## City of Albuquerque

February 7, 2003

**Re: Villa de Villagio Subdivision Drainage Report**  
**Engineer's Stamp dated 12-24-02 (A11/D9)**

BASIN MAP

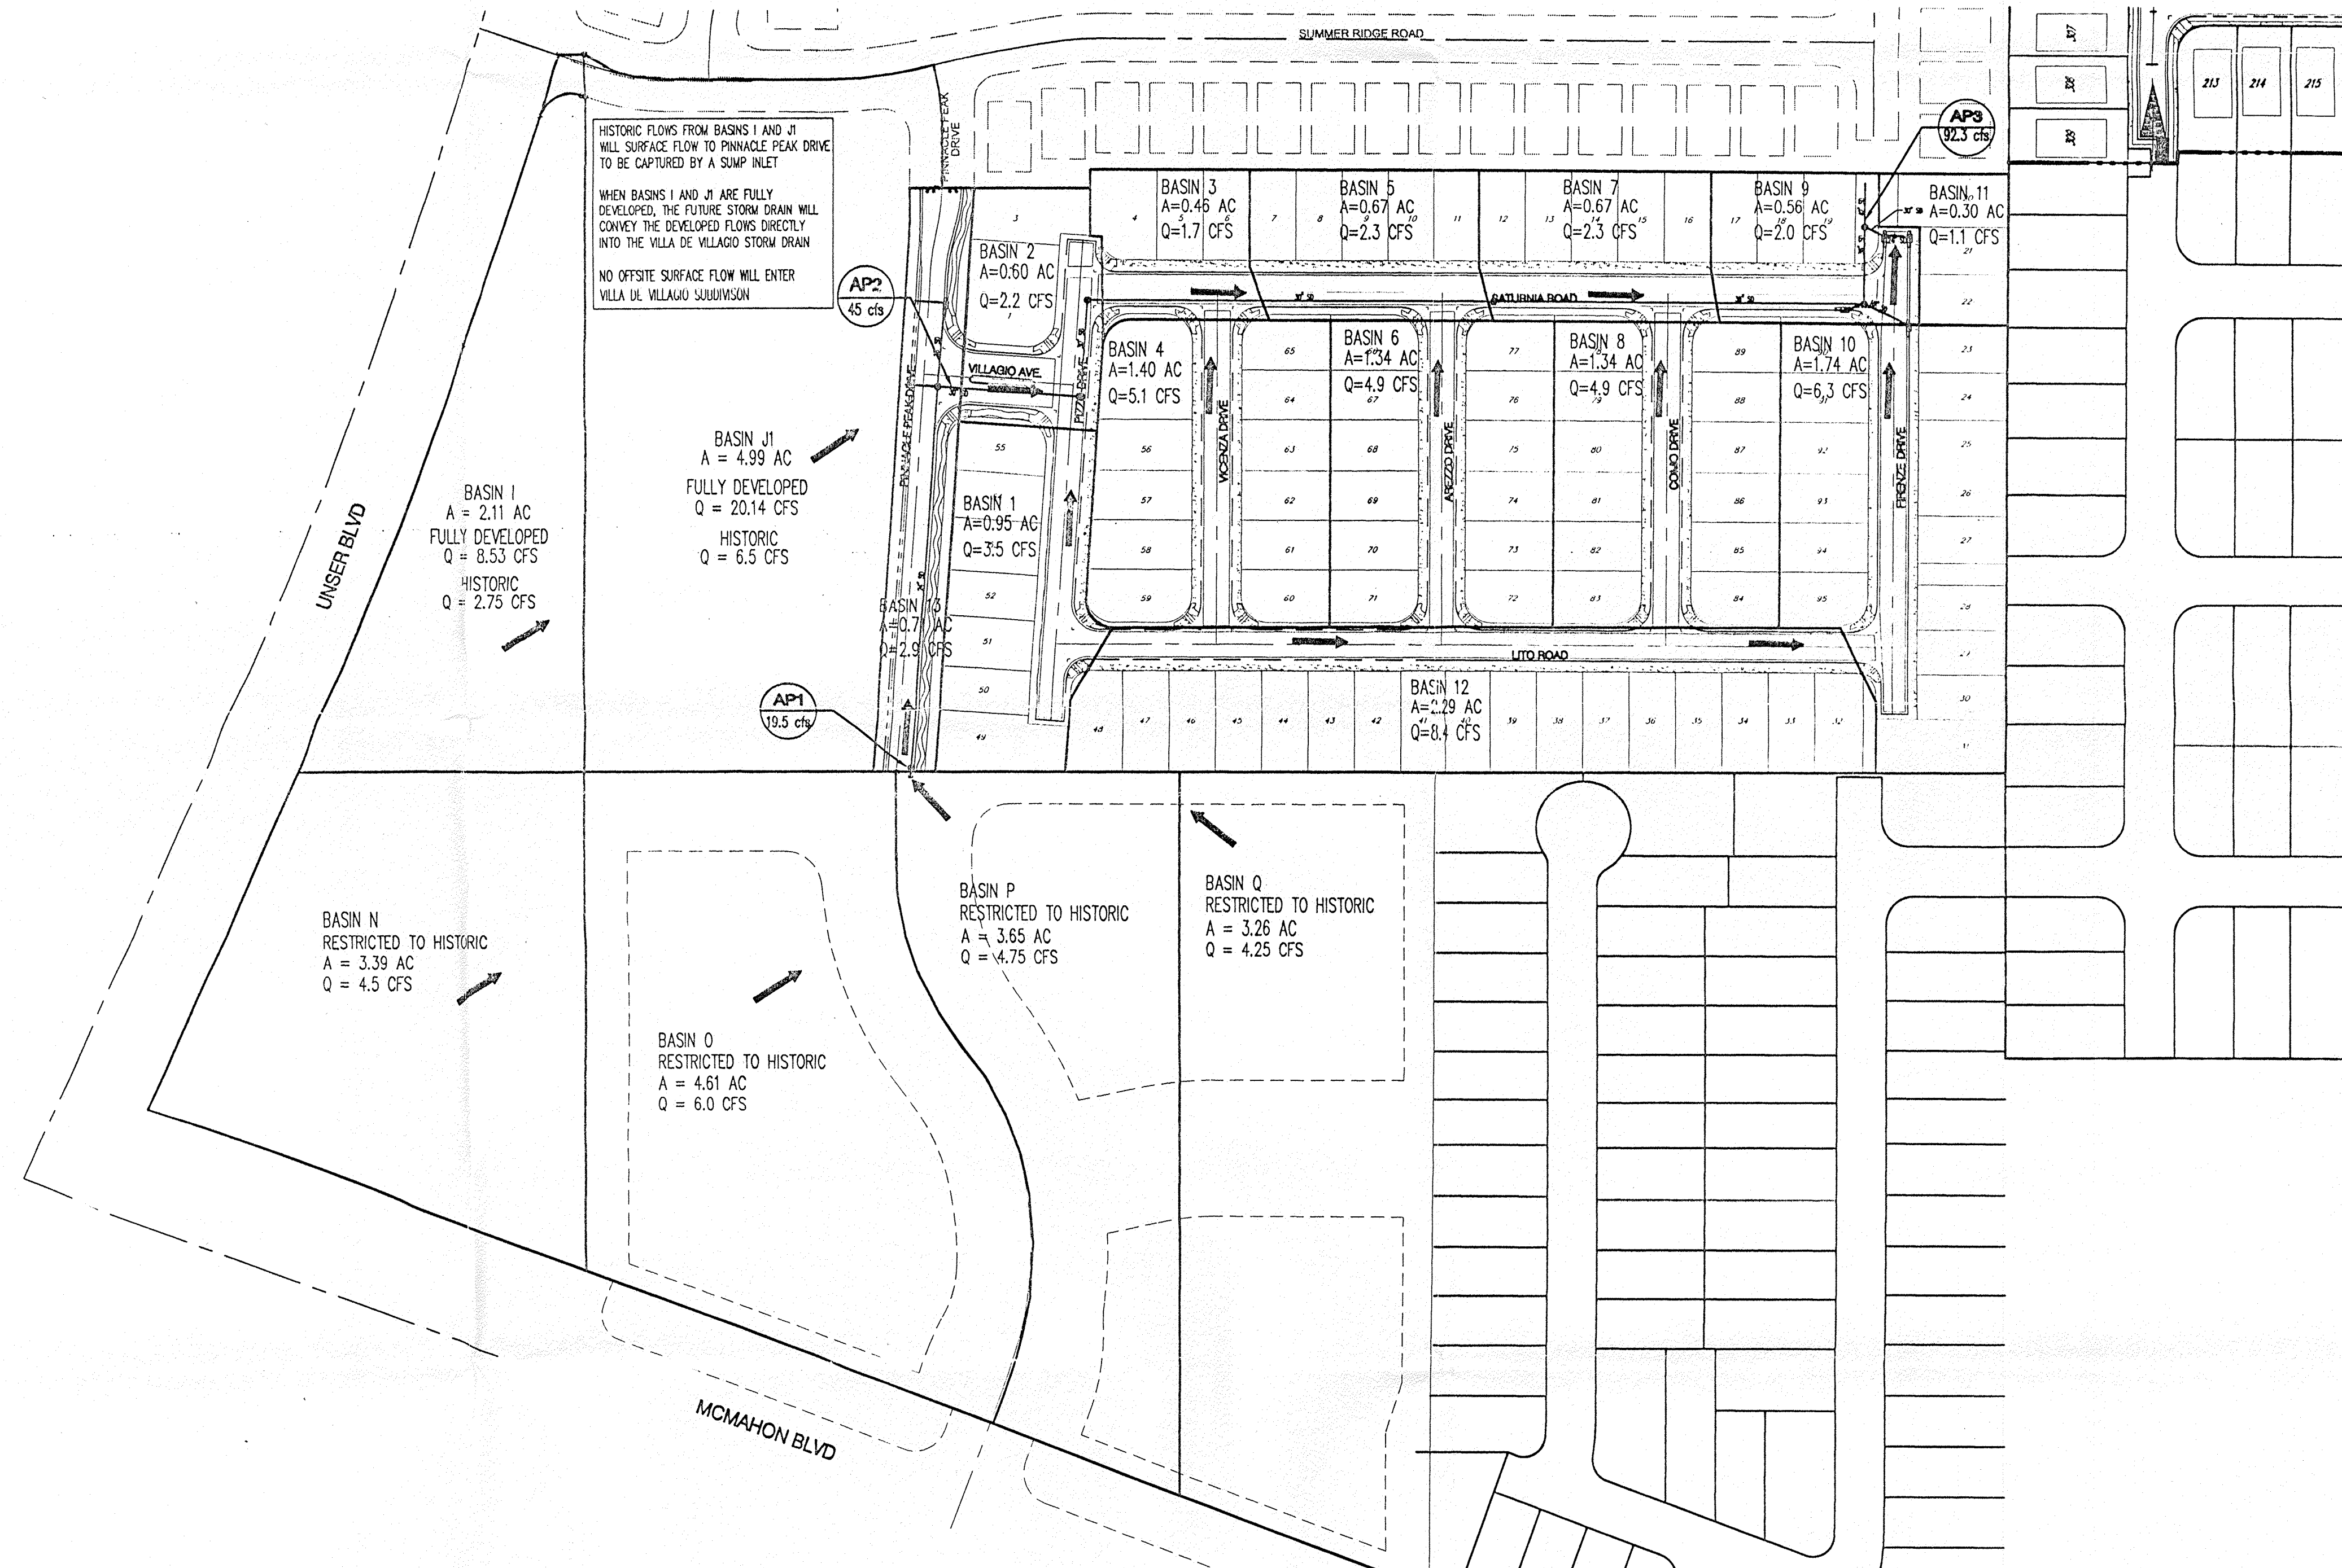
- Please provide the basin map (or other document) from the Ridgeview and Monterey Park subdivisions plus the Black Arroyo Master Plan to verify:
  1. the capacity available for APX,
  2. that Monterey Park drains to Stonebridge, and
  3. that the tracts mentioned are indeed restricted to historic runoff quantities.
- It appears a retaining wall will be needed on the boundary with Monterey Park subdivision. Or possibly, the adjoining spot elevations are in error.
- How is the undeveloped runoff from Tract J1 managed? It seems that it can't get to the Pinnacle Peak since the road is proposed to be built almost a foot higher than the existing contour. Please provide a conceptual profile for Pinnacle Peak from Summer Ridge to McMahon
